## WEST SUSSEX COUNTY COUNCIL CONSULTATION

| <b>DATE:</b>                    | 18 March 2019                                                                                                                                                                                                                                                                                                 |
| <b>LOCATION:</b>                | Land off Burndell Road Yapton.                                                                                                                                                                                                                                                                                |
| <b>SUBJECT:</b>                 | Y/98/18/RES<br><br>Approval of reserved matters (access, appearance, landscaping, layout and scale) following outline permission Y/19/16/OUT for 108 residential dwellings, with associated parking, road/footway/cycleway provision, open space, landscaping, surface water attenuation and ancillary works. |

6xIBF- Affordable.
2 storey
93-98

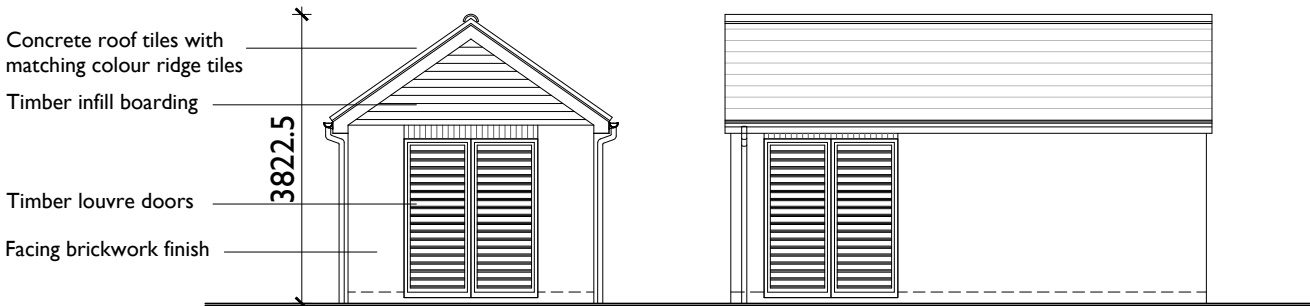
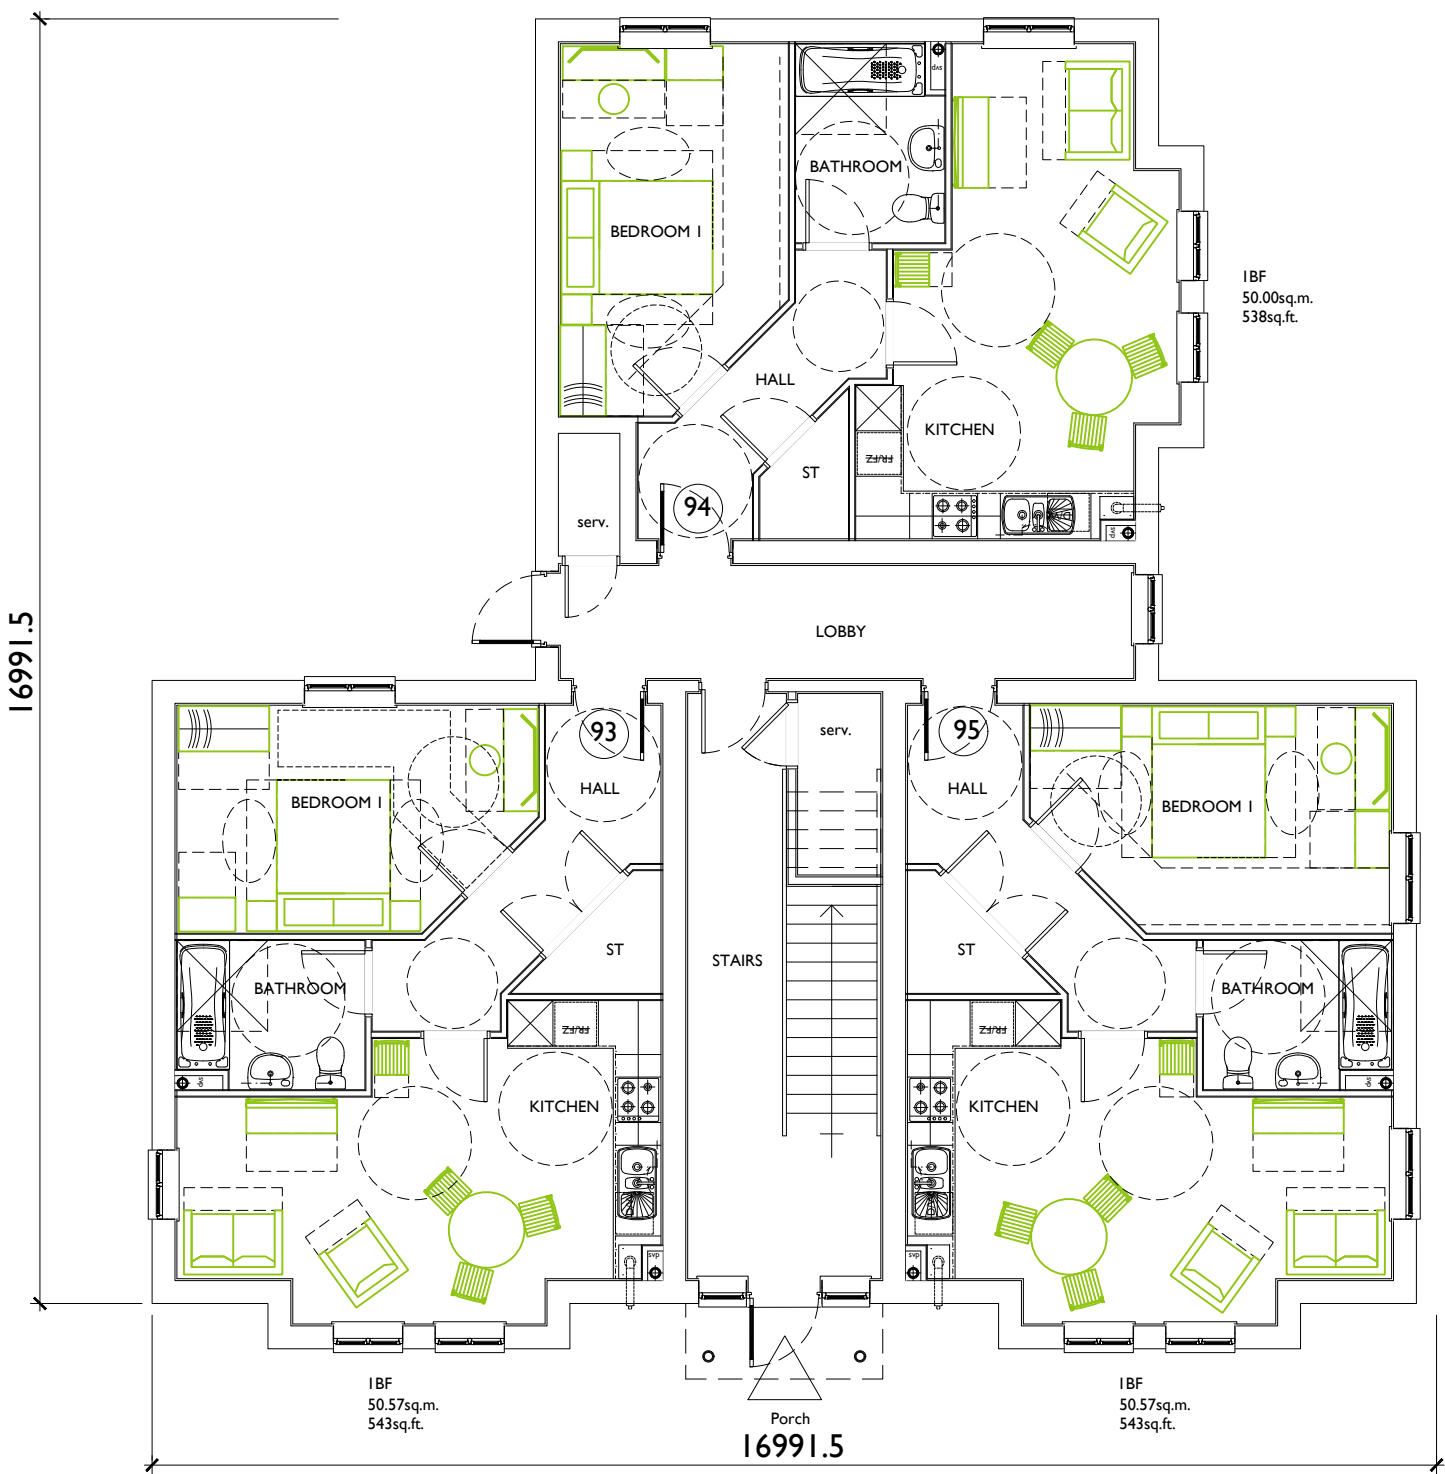
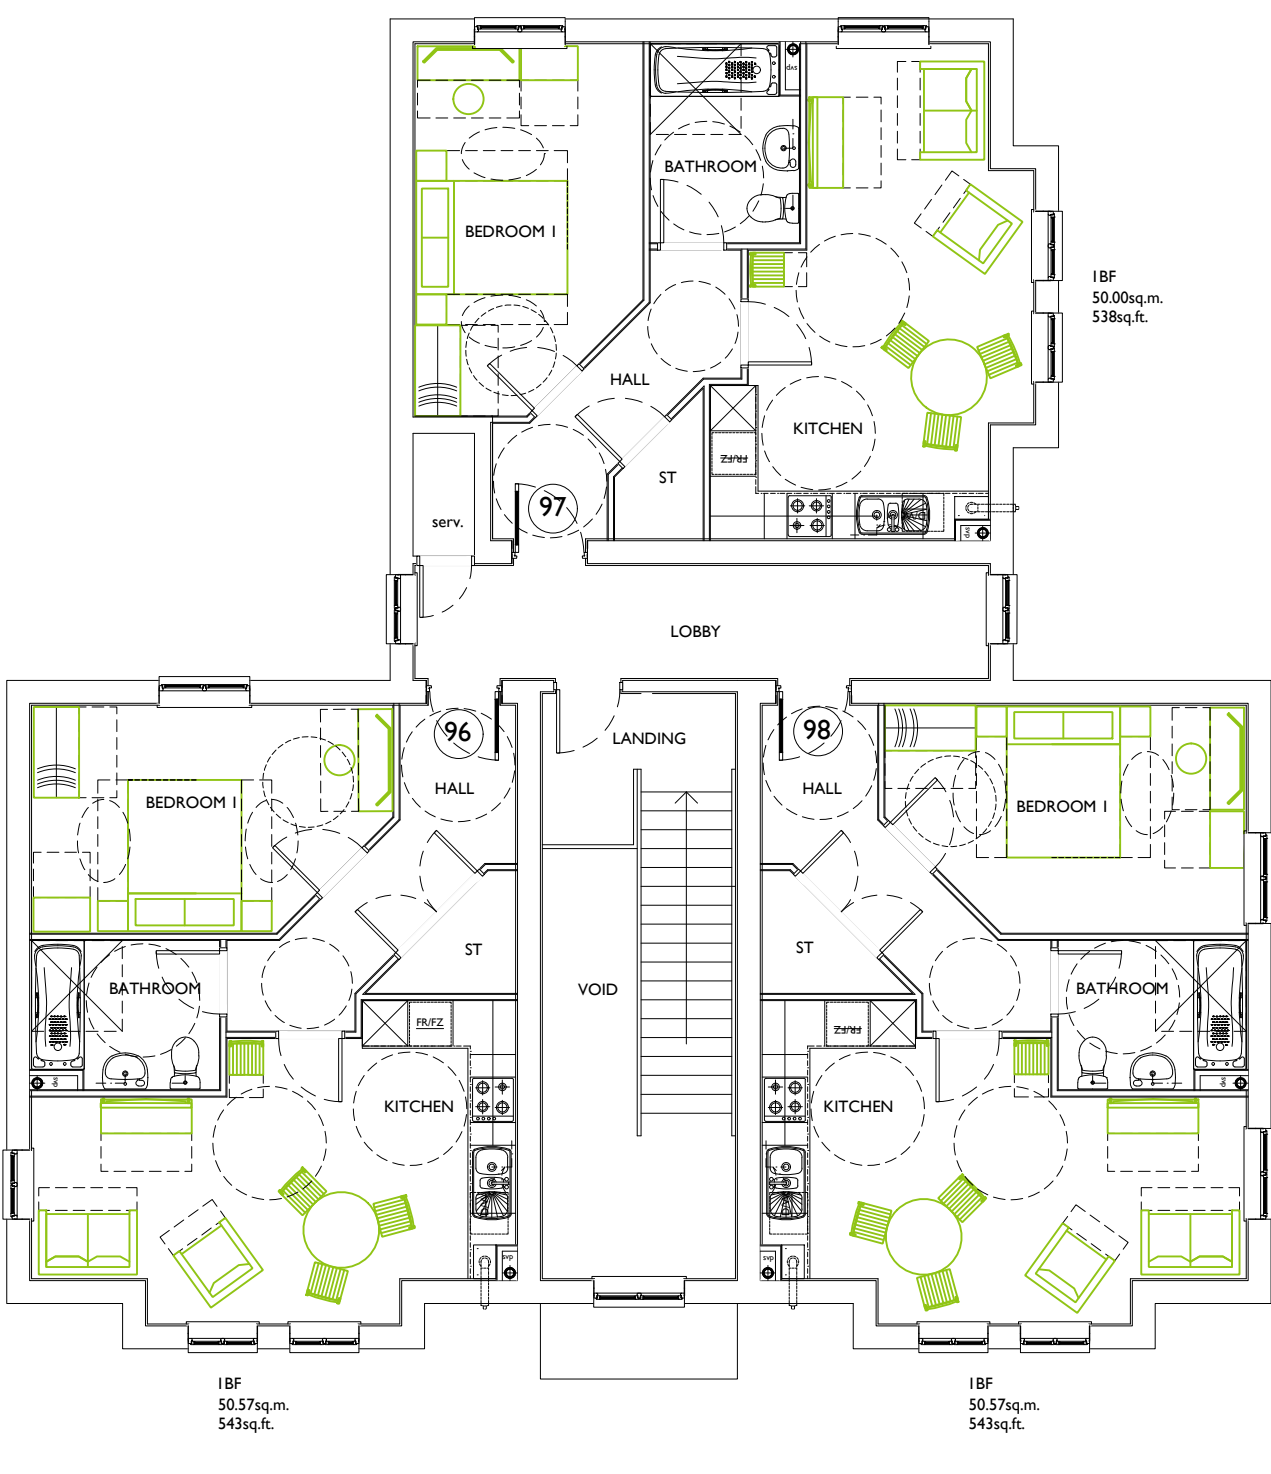
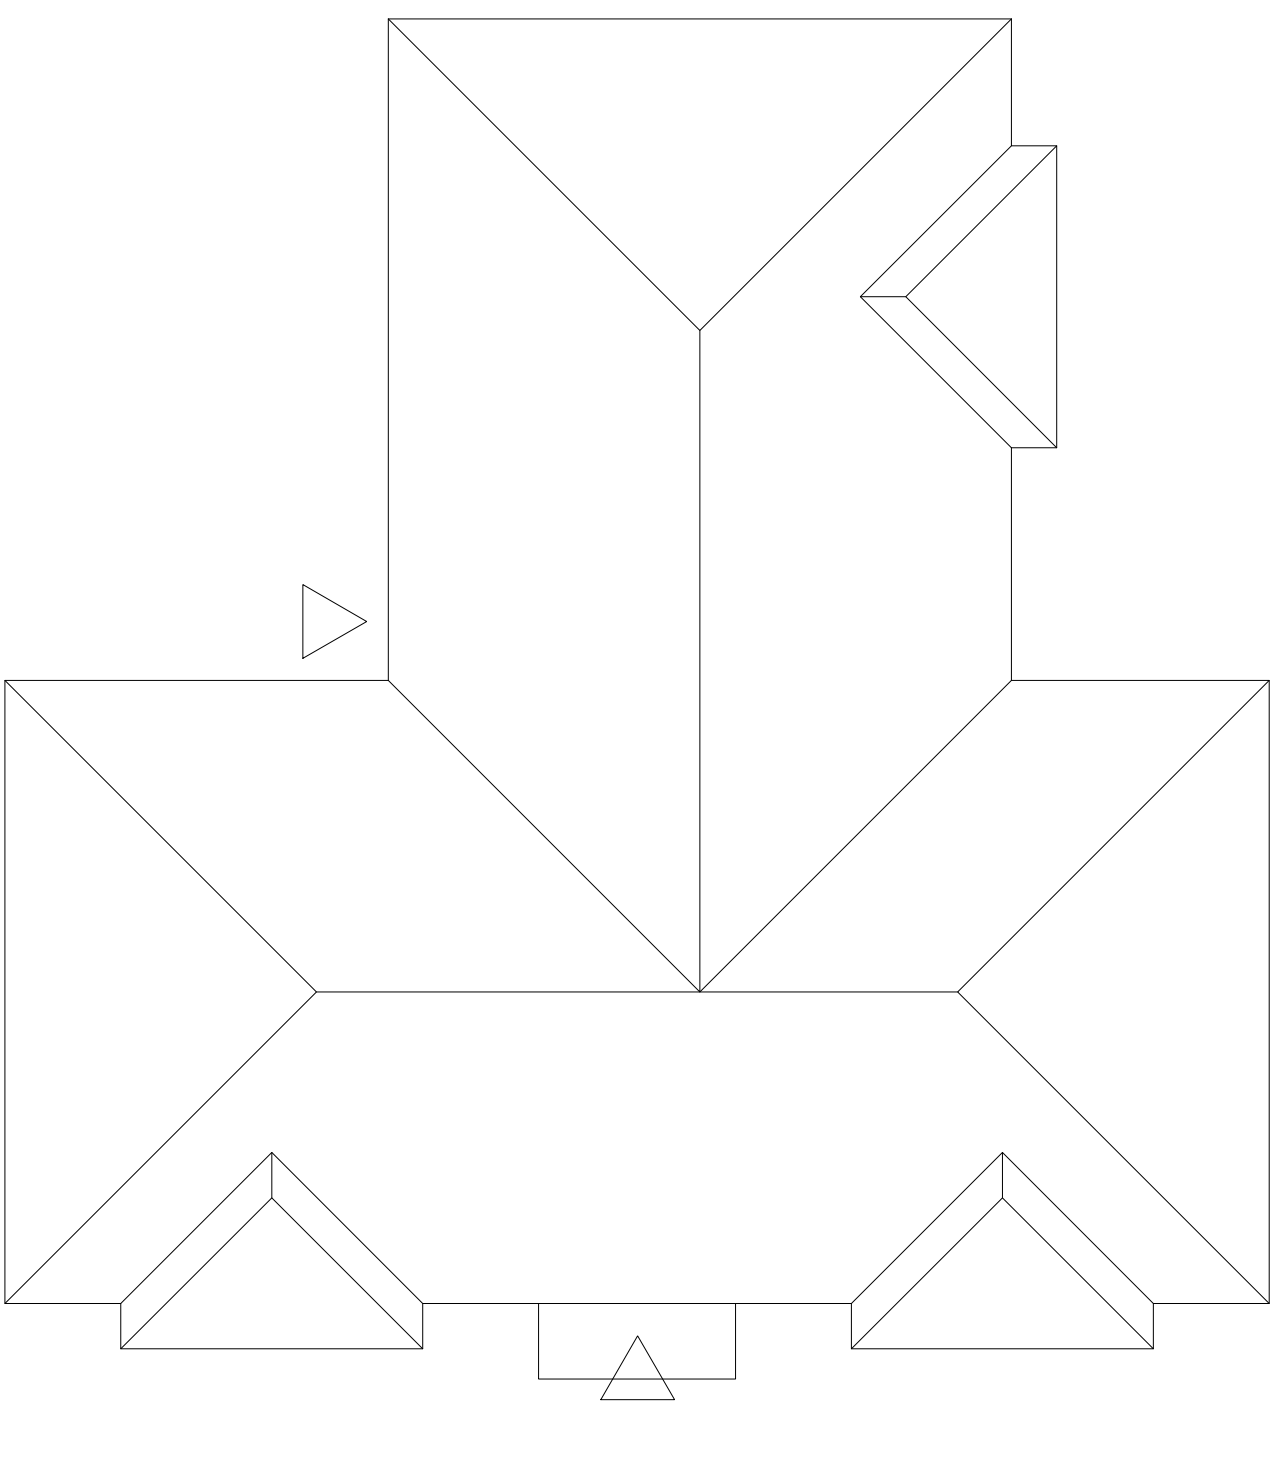
- 4. Condition 23 (cycle parking)** – The cycle parking for properties 93-98 (south-western corner of the site) now appears to be shown shown covered and secure.
